From: Martyn White <Martyn.White@arun.gov.uk>
Sent: 18 November 2019 12:22
To: Planning.Responses <Planning.Responses@arun.gov.uk>
Subject: WA/101/19/L

WA/101/19/L

The application relates to the conversion of an existing detached garage into ancillary annexe accommodation for a dependent relative. The garage, whilst of modern construction is located in the grounds of a Listed Building.

PROPOSED ELEVATIONS

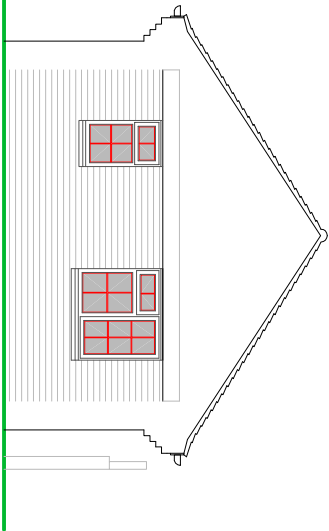
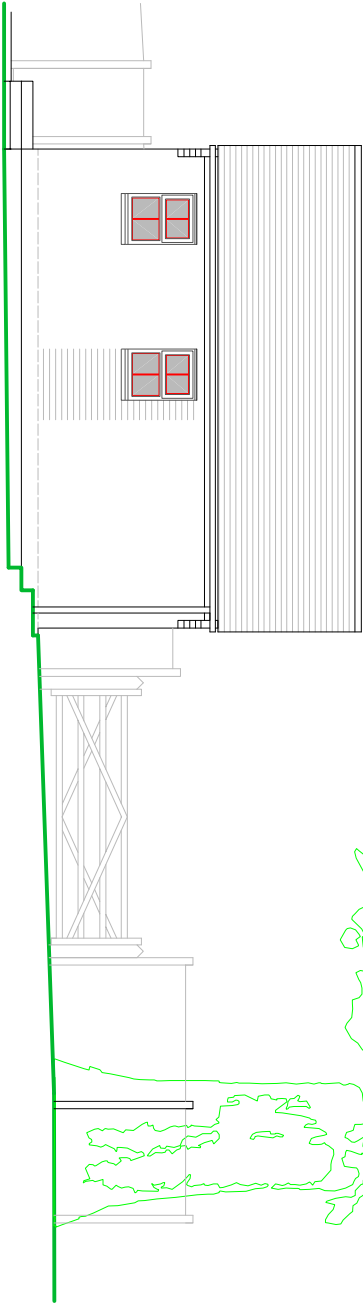
The external works involve a number of additional windows and a door. It is noted that these will be white painted and wooden, and that the glazing will consist of the 'slimlite' double glazed units. Both the materials and glazing are considered to be acceptable as they respect the character of the main listed building. Details of the joinery will be required by way of condition in order to ensure that they are suitable in terms of their appearance.
